From: Anna Gillings [REDACTED]
Sent: 25 November 2021 16:18
To: Anita Gardner <Anita.Gardner@arun.gov.uk>
Cc: Emma Patchell <[REDACTED]>
Subject: FW: Dappers Lane - Drainage- OWC application

Subject: RE: Dappers Lane - Drainage

Please find attached the offsite Drainage Works Drawing in order to show and detail the requested works and to accompany the Land Drainage Consent Application for the proposed development on Dappers Lane, Angmering. If you have any comments or questions please don't hesitate to get back to me as soon as possible.

PERMEABLE BLOCK PAVED CAR PARK & DISTRIBUTION TANK DETAIL

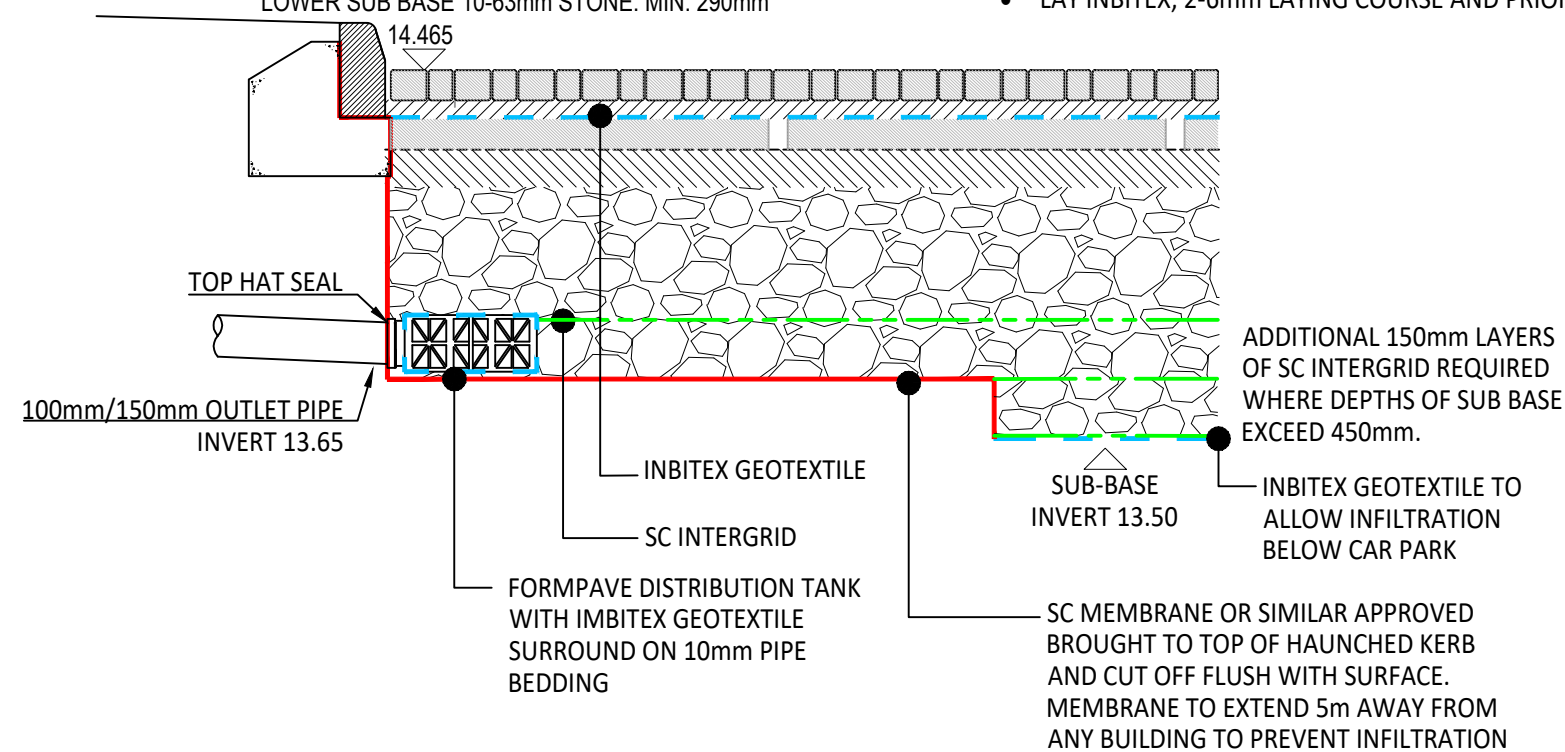
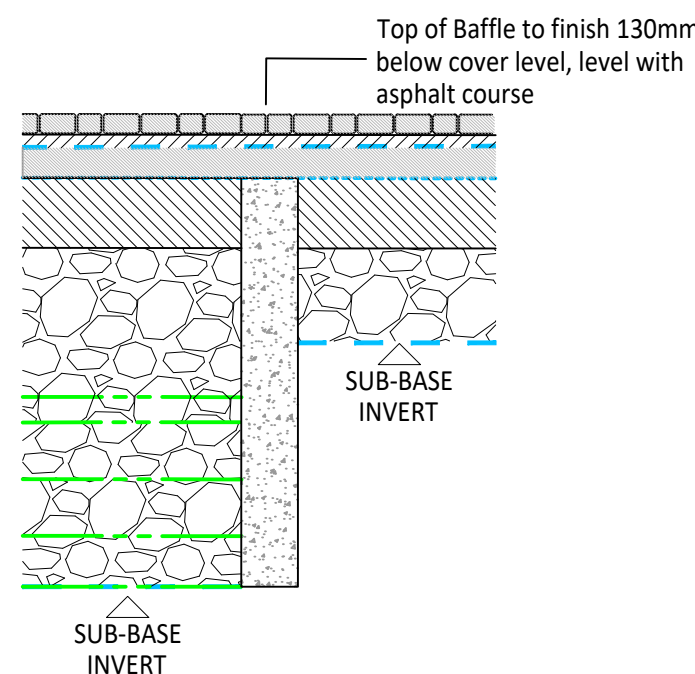
6. A construction detail drawing of the permeable paving is required. Including additional details showing diffuser block connections, and baffles. *Detail showing distribution tank does not appear to have been supplied. Awaited*

7. Please provide construction detail of permeable paving which is shown to not have a permeable sub-base. *Is this shown by the area with the SC membrane on the permeable block paved car park detail?*

ACO SWALE INLET DETAIL

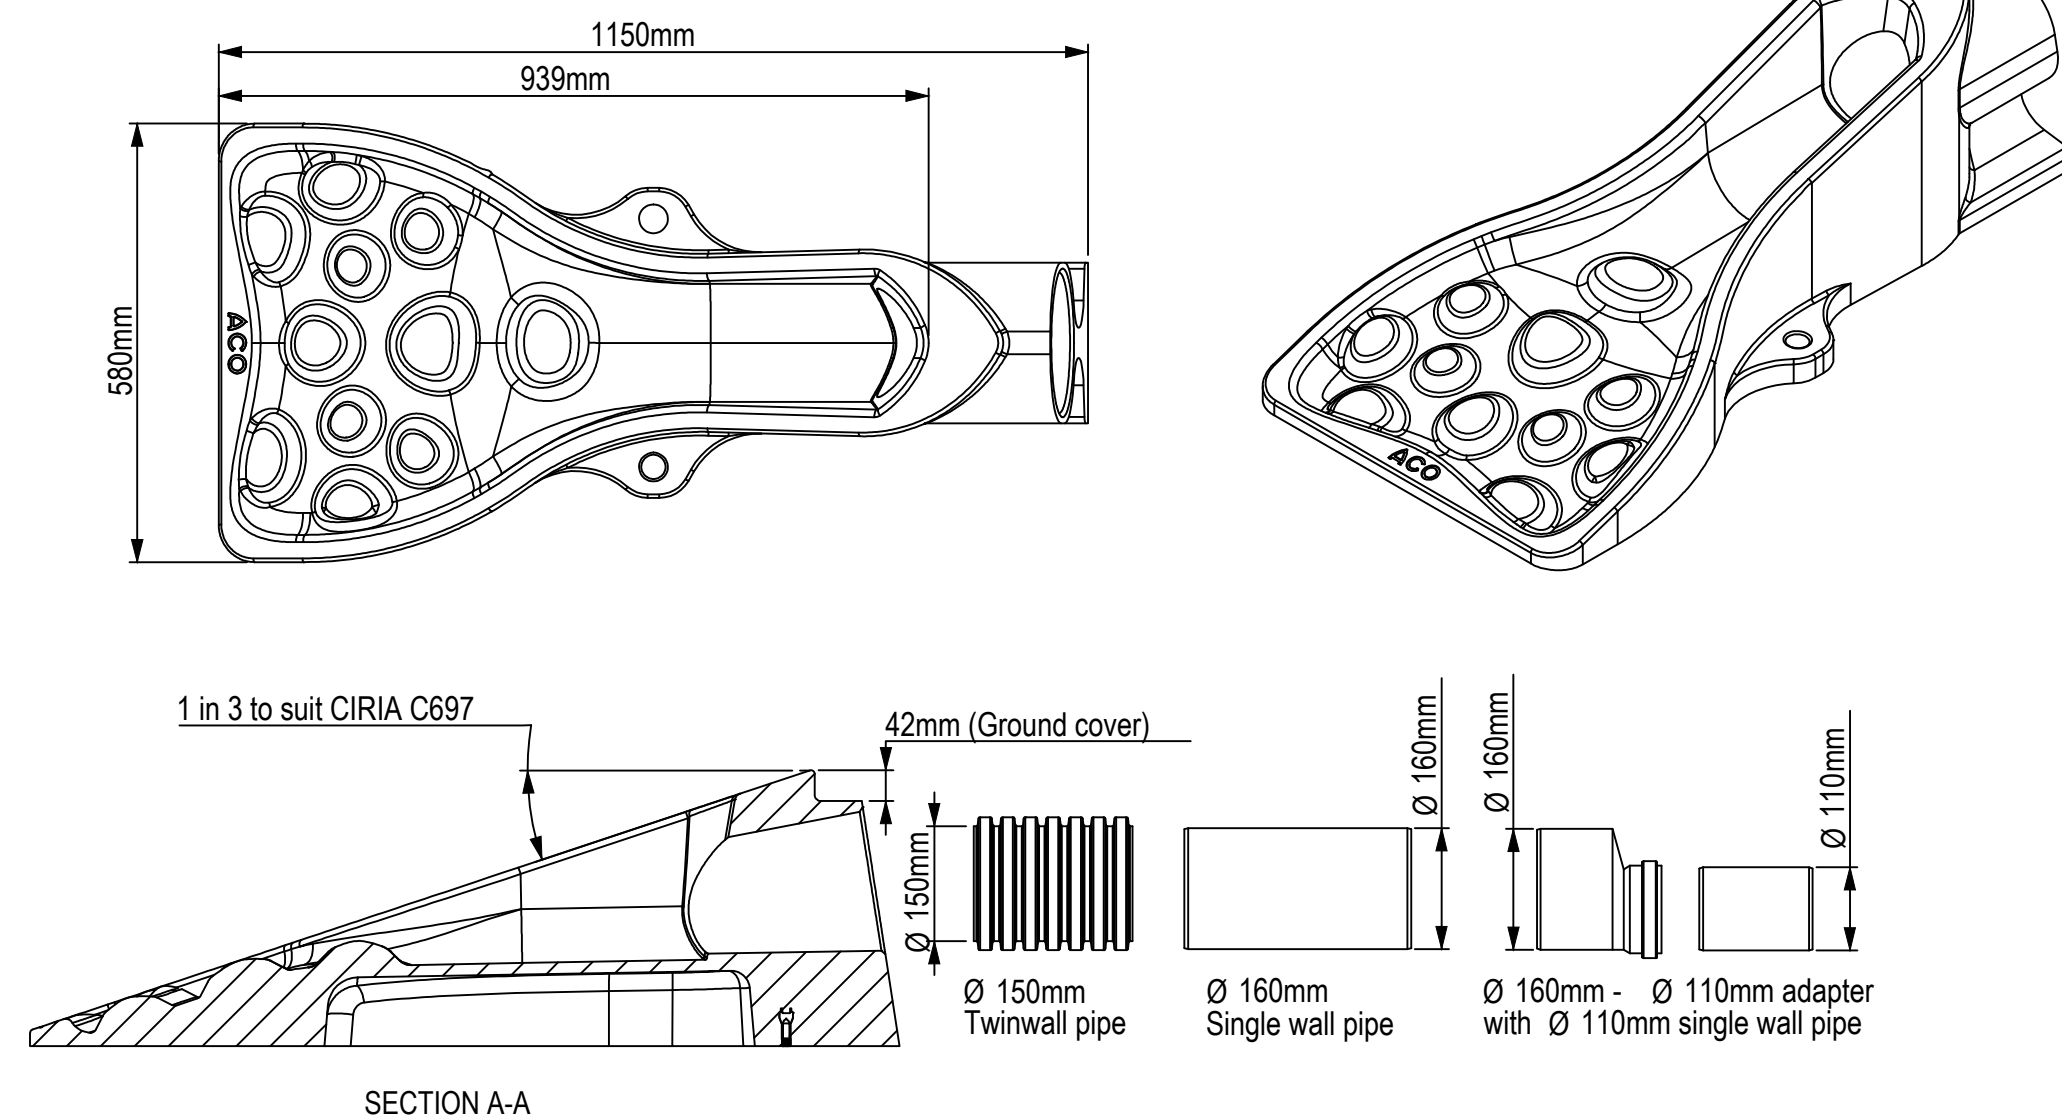
5. Please provide construction detail drawing showing swale cross section, long section, ACO inlet detail in relation to swale, connection between swale and ditch. *Await comments regarding proposed connection to ditch from a land drainage consent perspective.*

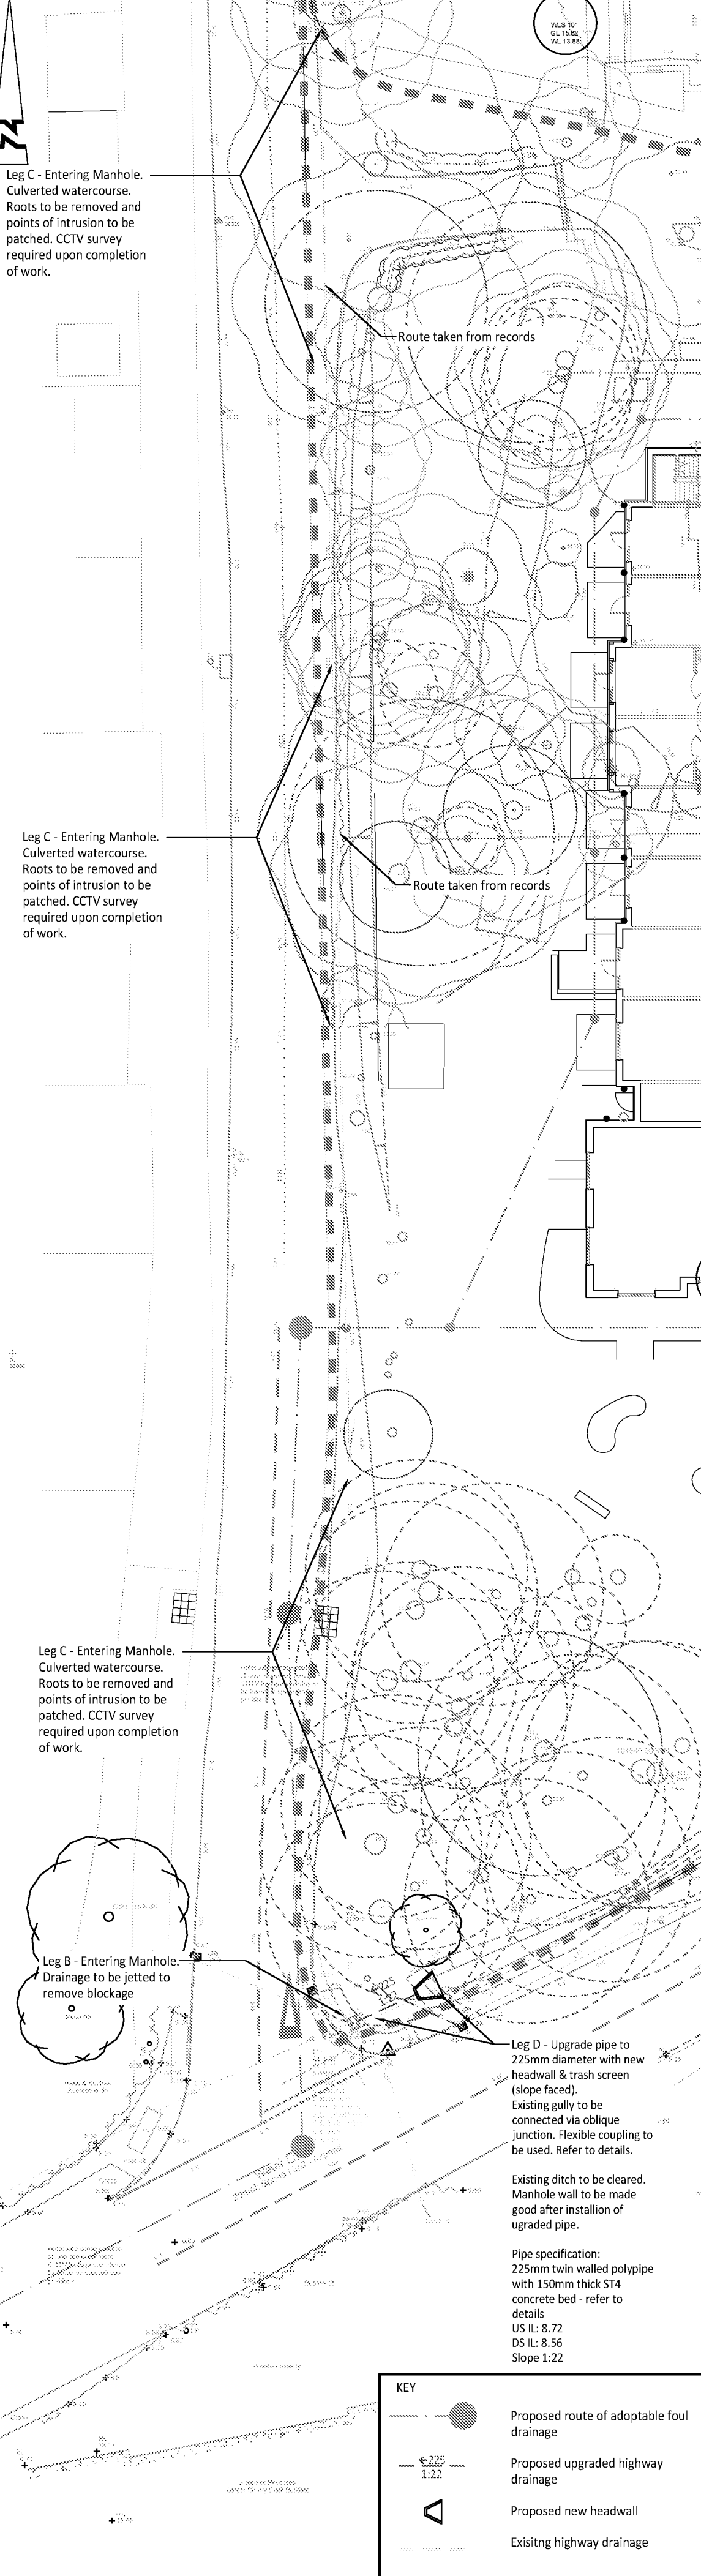
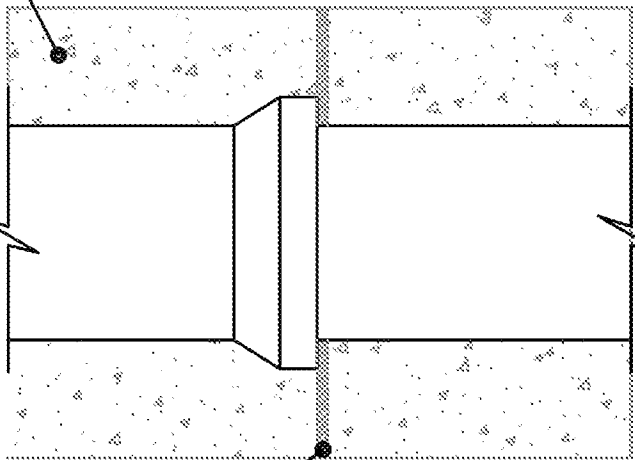
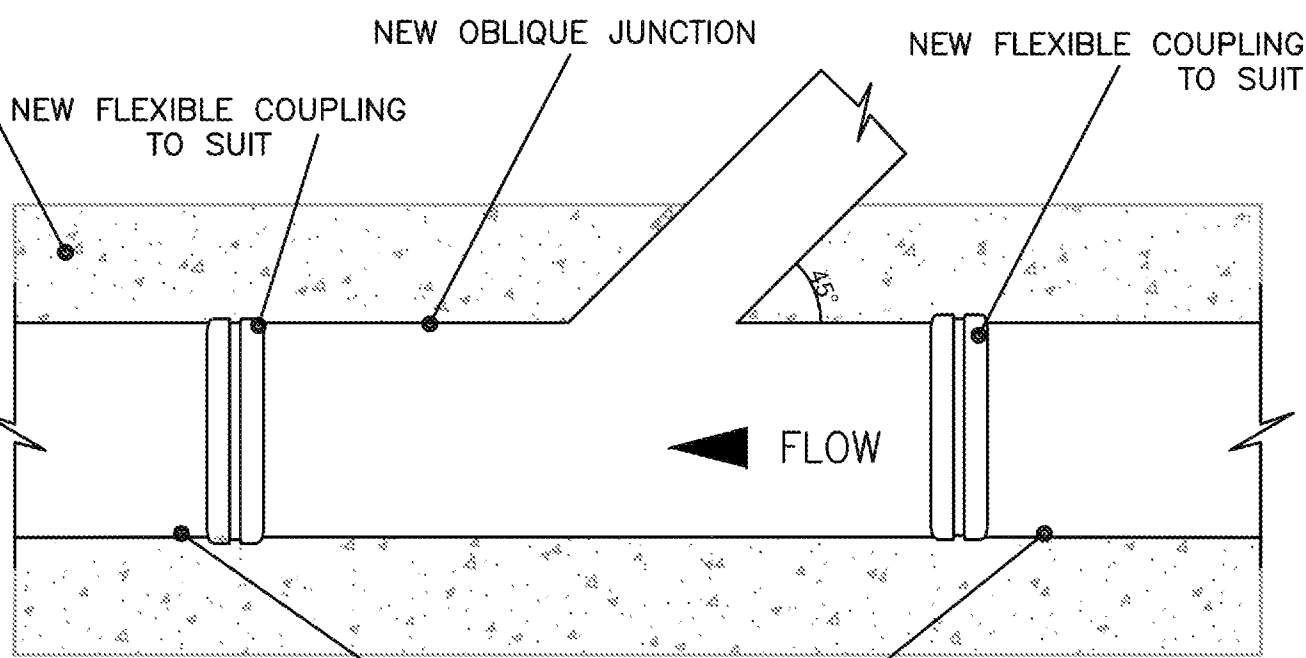
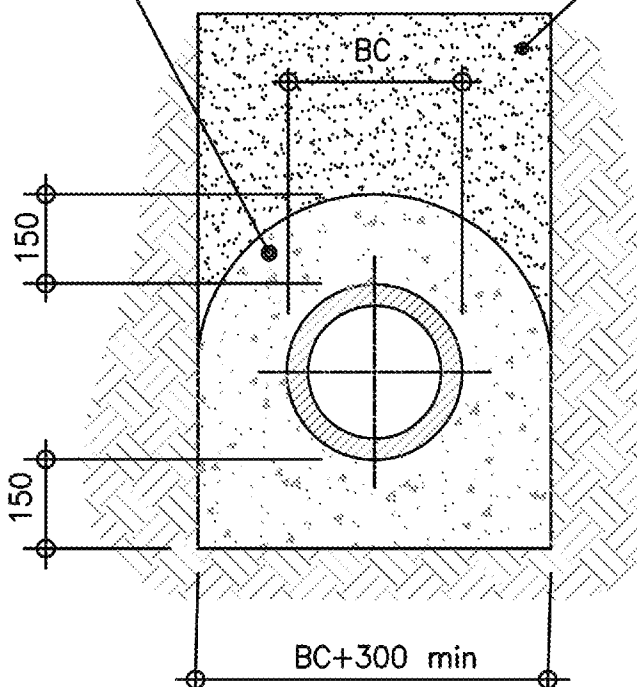
3. Please could you colour the culverts/ditch on the offsite drainage works plan to make them clearer.
4. Proposed headwall & Leg 'D';
 - a) Specify invert levels of proposed 225mm pipe.

- b) Brickwork refers to note 3 but should be note 2.
 - c) Show how the post & rail fence will be bolted to the headwall.
 - d) Please adjust the proposed trash screen design to utilise this one or very similar; 225mm Sloped Trash Screen with Sides 45 degrees | Althon

- e) Entry into existing manhole – make good manhole wall as necessary – add note.
 - f) All pipework to be twin walled polypipe or similar approved with 150mm thick ST4 concrete bed and surround with expansion joints. Add suitable note/detail. See enclosed drawing to assist.

- g) Gully connection – existing lateral to be joined to new pipework/oblique junction using a 'flexible' coupling – add note.
5. Leg 'B' - proposals noted thank you.

6. Leg 'C' – proposals noted but ensure entire length of culvert adjacent the site boundary is shown.
7. Leg 'X' - Undertake further CCTV survey to enable completion of previous survey to Black Ditch – Present findings so further discussions can be had.

8. Note '*Connection to be remade to upgraded pipeline between MH1 and ditch*' shown in wrong location.
